# BICESTERBUG

## **Interim Submissions on Pioneer Roundabout Planning Application 20/01830/F**

**24 August 2020**

Drawing 3: Proposed Site GA Plan (Drawing ref. WIE11386-145-03-001)

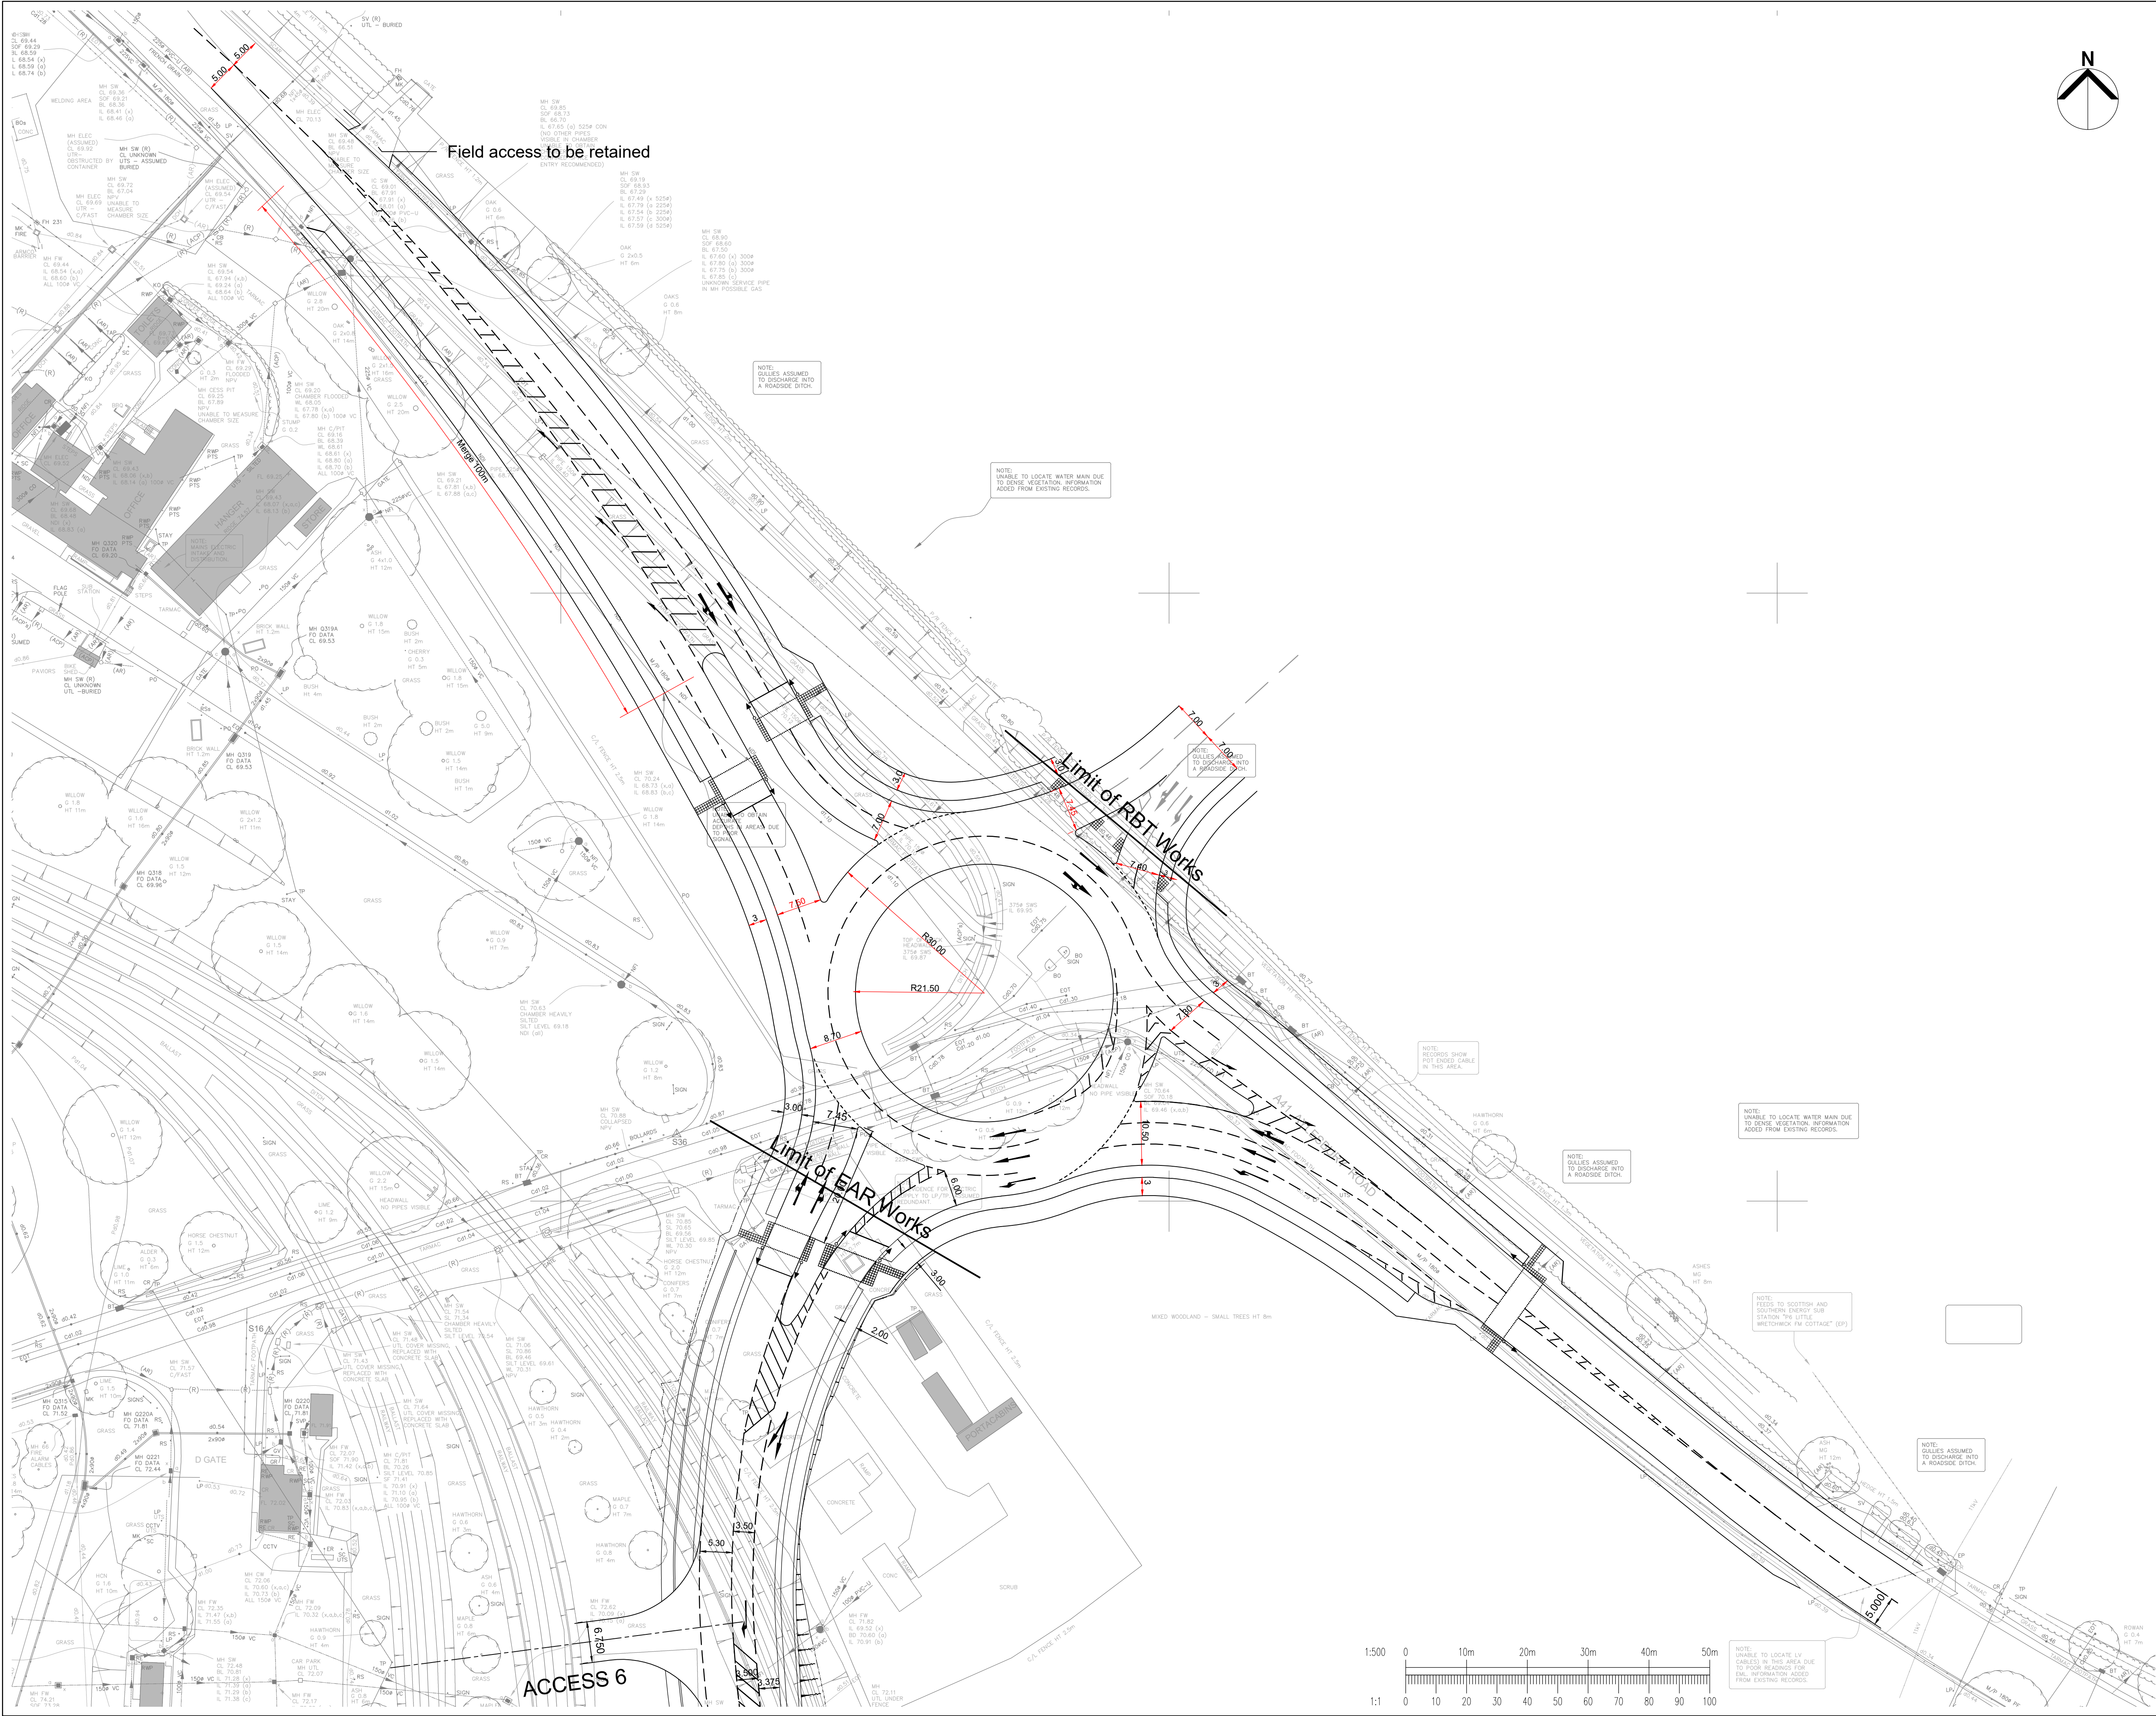
The current roundabout design is problematic in that it is grossly over capacity for motor vehicle traffic, making it costly and dangerous. The design replicates the disastrous design issues that have plagued other roundabouts in Bicester such as the Vendee Drive Roundabout, the Bicester Village Roundabout, and the Rodney House Roundabout.

The gross over capacity makes it impossible to provide suitable provision for pedestrians and cyclists, in breach of the provisions of the Cherwell Local Plan, compliance with which is a legal requirement.

The problem stems from the wide, swept, approaches that result from the emphasis on high capacity and high-speed vehicle movements. In such a design, crossings can only be safely placed at a considerable distance from natural desire lines. For instance, the crossing on the A41 Aylesbury arm is almost 50 metres from the natural desire line.

In addition, high speed junctions limit the types of crossings that can be deployed, and the locations where they can be deployed. Designing to accommodate motor vehicle speeds of 40mph around the roundabout and with 3-lane wide carriageways limits the possible crossing choices to traffic light-controlled crossings, which are one of the least accommodating of active travel. In addition, traffic-light controlled crossings are required to be placed away from the give way point on a roundabout (and hence away from the natural desire line) so as to avoid causing confusion to motor vehicle drivers. It is for that reason that LTN 1/20 (2020) points out at 10.4.5: 'In many situations, reducing the speed of motor traffic using the carriageway will enable additional options for the crossing design to be considered.'

The design could be substantially improved by taking a more measured approach to the motor vehicle capacity and by designing the roundabout for slower speeds. Following the Dutch approach to roundabout design, the approaches to the roundabout could be straightened to improve visibility of pedestrians and cyclists and the geometry could be constrained to discourage unlawful speeding. This would then permit the pedestrian and cycle crossings to be placed very close to the natural desire lines, and for the crossings used to be those that are much more accommodating of pedestrians and cyclists, such as zebra or parallel crossings. Thought could also be given to crossings that would permit cyclists (who move more swiftly) to cross the carriageways in one movement rather than two (as with pedestrians).

Finally, in the light of the recent introduction of LTN 1/20, the design needs to be reviewed to take into account this guidance, for example the depreciation of shared pedestrian and cycle paths and corresponding requirement for segregated paths.
